KITTITAS COUNTY

MEMORANDUM

TO: All Staff
FROM: Public Works Plan Review Team
DATE: July 20, 2026
SUBJECT: CB-26-00002 Ross

Homesite 7-4 and 7-5 # Wanawish Loop

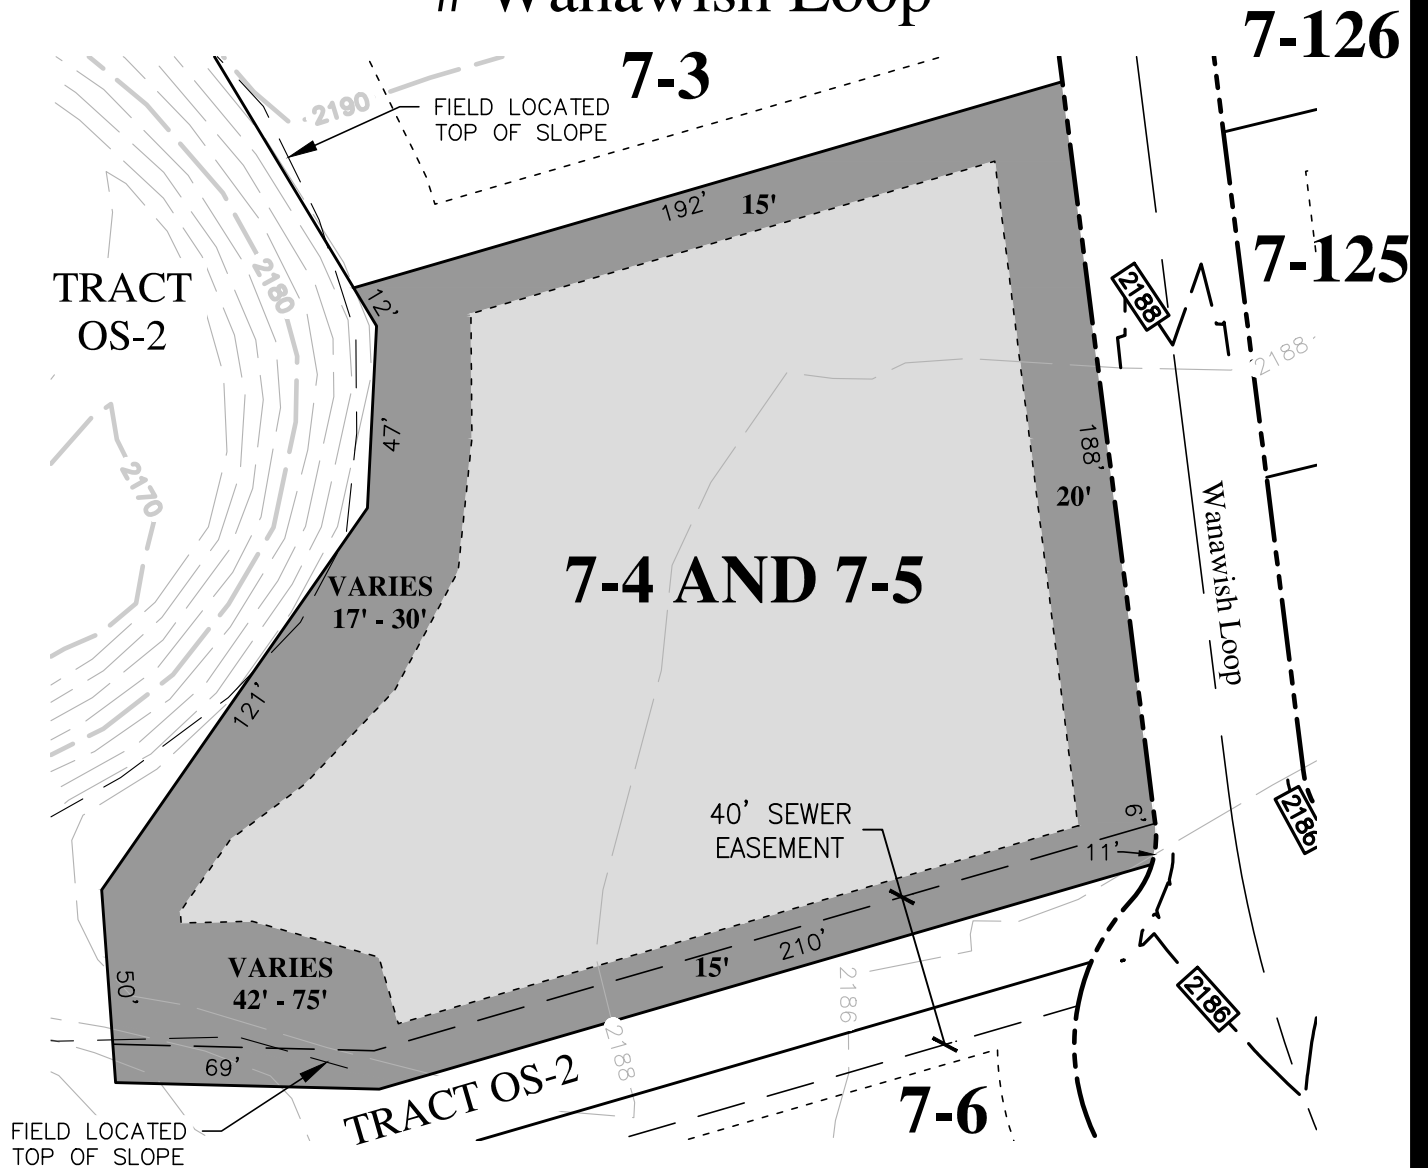
ACCESS	1. The Tax Parcels are located within Suncadia and fall under the Suncadia Development Agreement. Any additional access shall comply with Suncadia's road agreement.(RC) Of Note: Property to retain address of 1920 Wanawish Lp. Cle Elum, WA
ENGINEERING	Except as exempted in KCC 14.05.060, no grading or filling upon a site involving more than one hundred (100) cubic yards shall be performed without a grading permit from the County Engineer or Public Works designee (KCC 14.05.050). An application for grading in excess of five hundred (500) cubic yards shall be accompanied by an engineered grading plan (KCC 14.05.080). (CBP)
SURVEY	There are no survey comments regarding this application. (JT)
TRANSPORTATION CONCURRENCY	No Comment. (RC)
FLOOD	No comments. (SC)
WATER MITIGATION/ METERING	No comments. (SC)
AIRPORT	No Comment. (RC)
